**PLANNING ACT 2008
APPLICATION BY HIGHWAYS ENGLAND FOR AN ORDER GRANTING
DEVELOPMENT CONSENT FOR THE A303 SPARKFORD TO ILCHESTER
DUALLING
SUBMISSION MADE PURSUANT TO DEADLINE 8**

PLANNING INSPECTORATE REFERENCE TR010036

PLANNING ACT 2008 - APPLICATION BY HIGHWAYS ENGLAND FOR AN ORDER GRANTING DEVELOPMENT CONSENT FOR THE A303 SPARKFORD TO ILCHESTER DUALLING

SUBMISSION MADE PURSUANT TO DEADLINE 8

Location

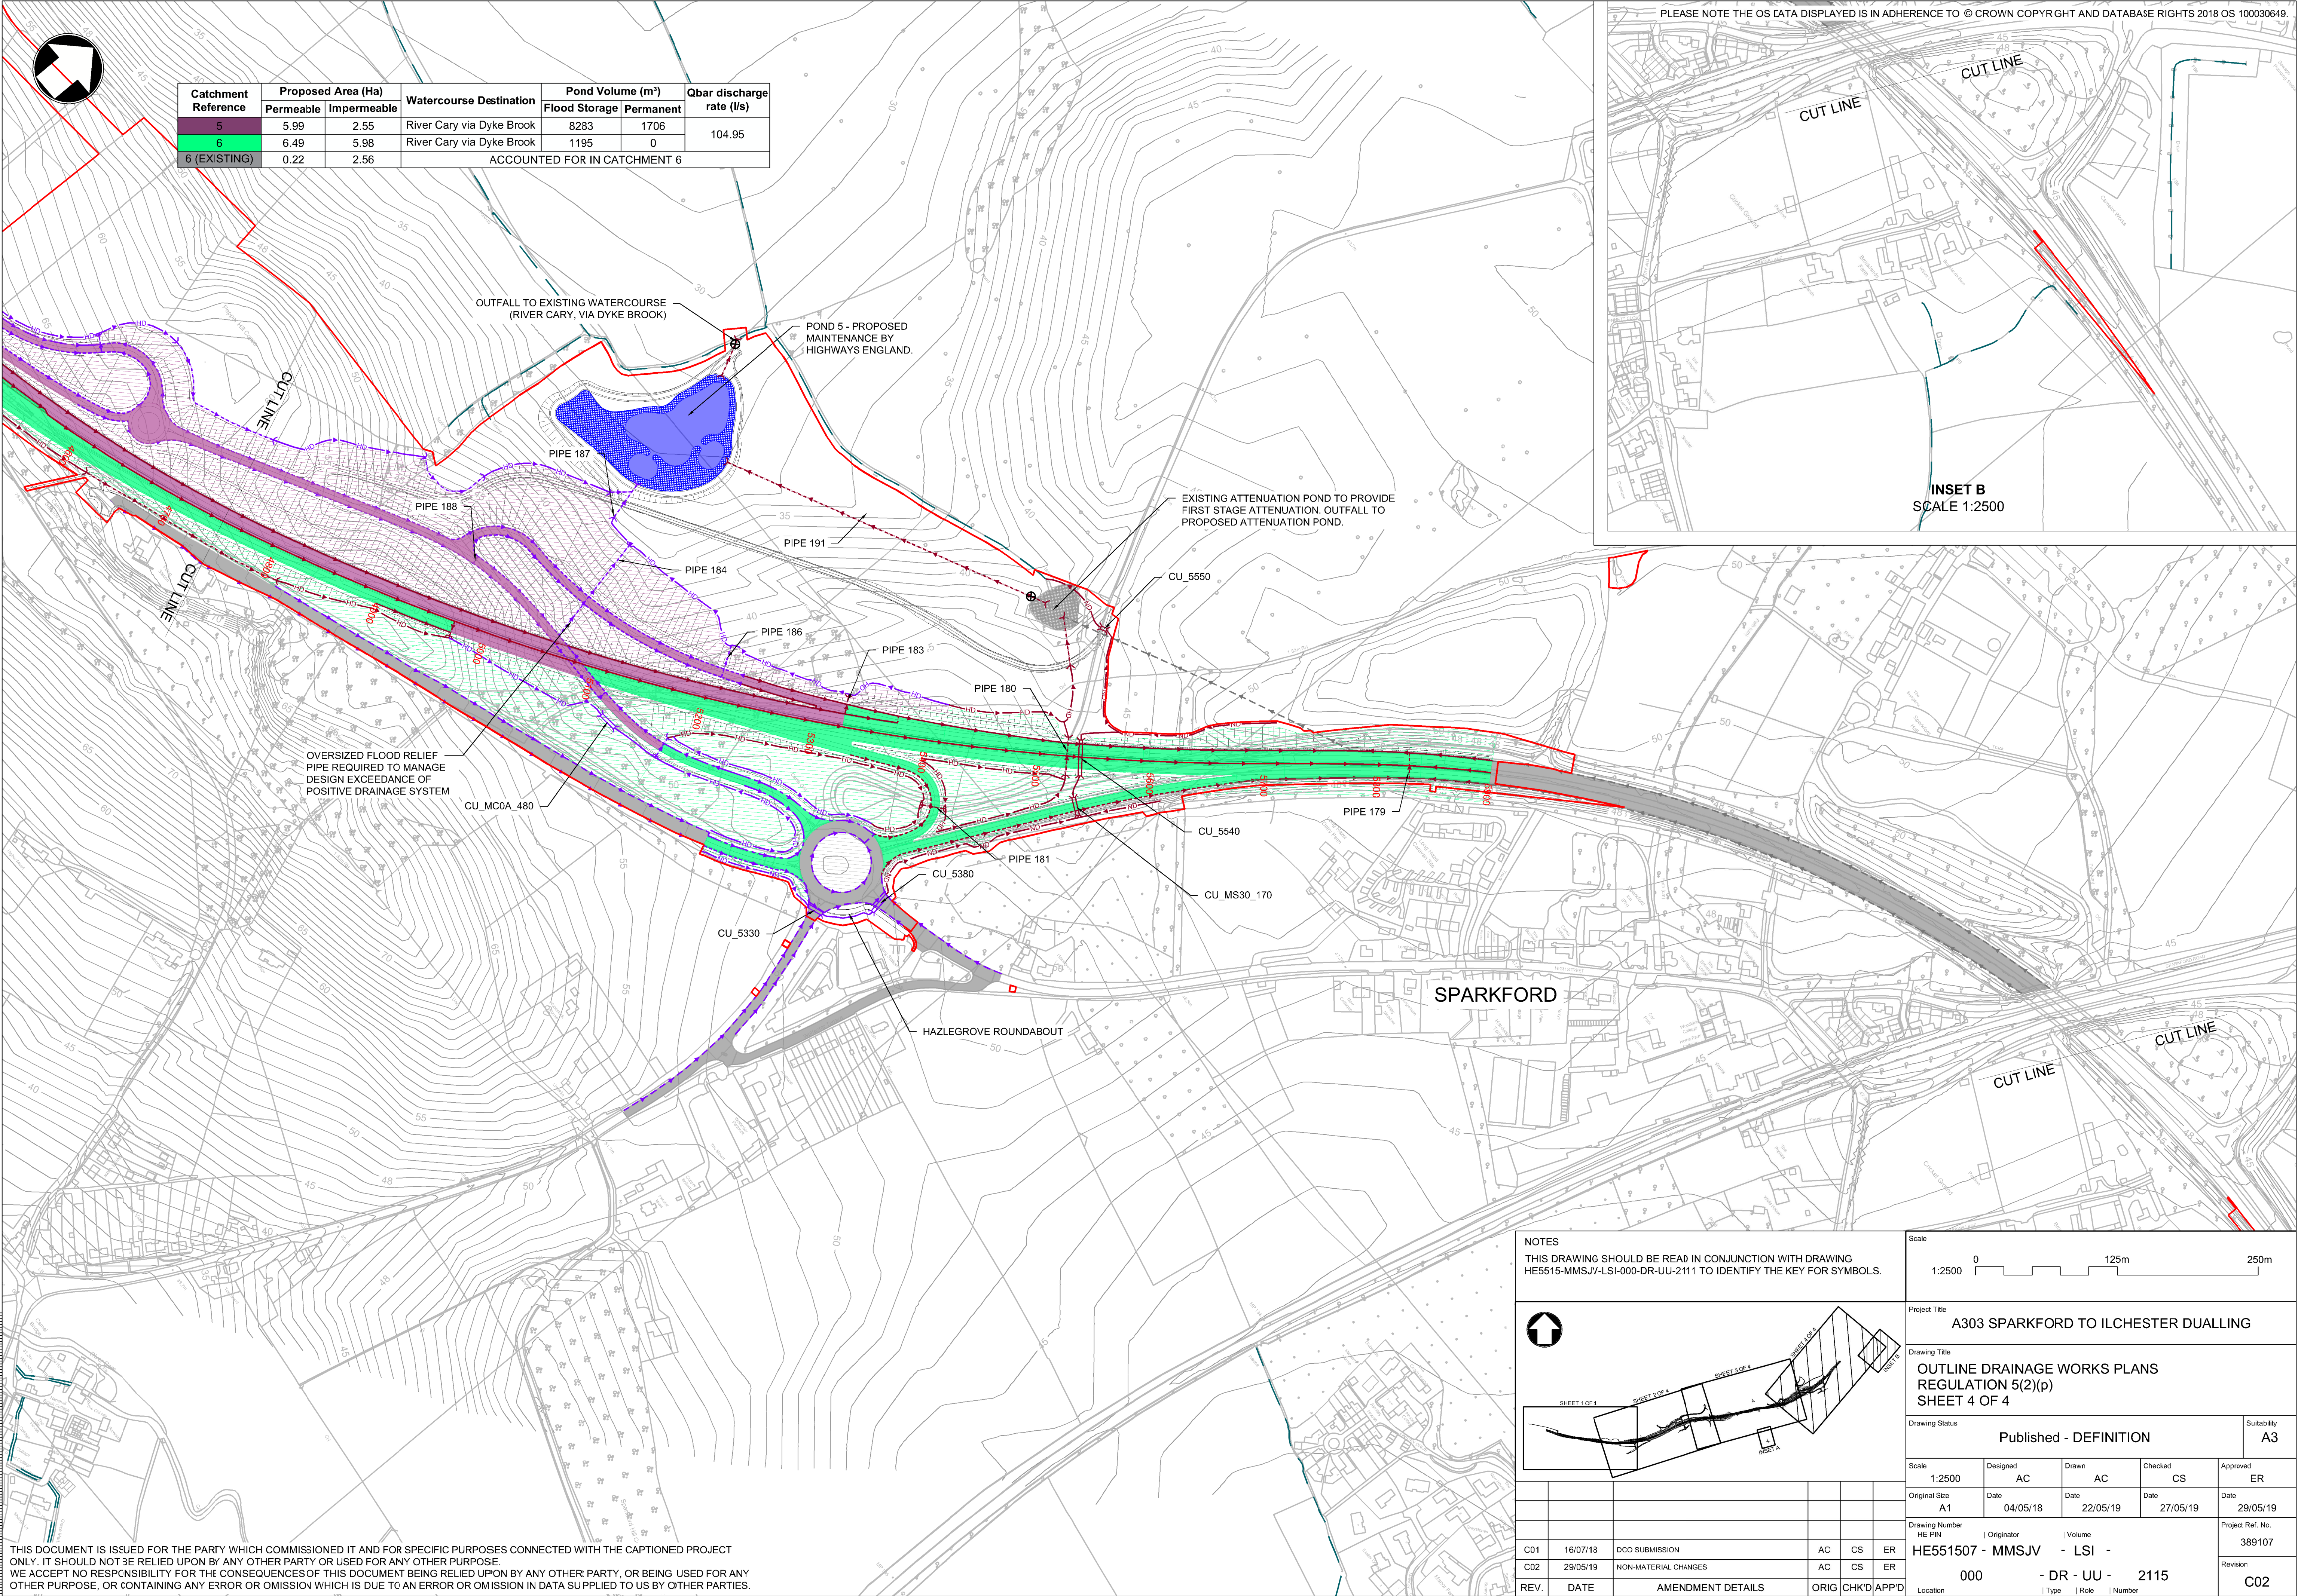
Taking drainage as an example - The Outline Drainage Works Plans separate the highway drainage into catchment areas. The catchment areas discharge to one of the 5 no attenuation ponds. The exception is at tie-in points of new construction with minor roads where the minimal increase in runoff will most likely discharge to existing ditches or gullies, as per the existing arrangements, though the detailed design will confirm if this will be the case.

In order for the LHA to be satisfied that all drainage works have been completed, the drainage infrastructure from the LRN to the receiving attenuation pond, the construction of the pond itself and the outfall into the adjacent watercourse will need to be fully completed. This will provide the satisfaction to the LHA that the LRN has been completed as per the TA drawings.
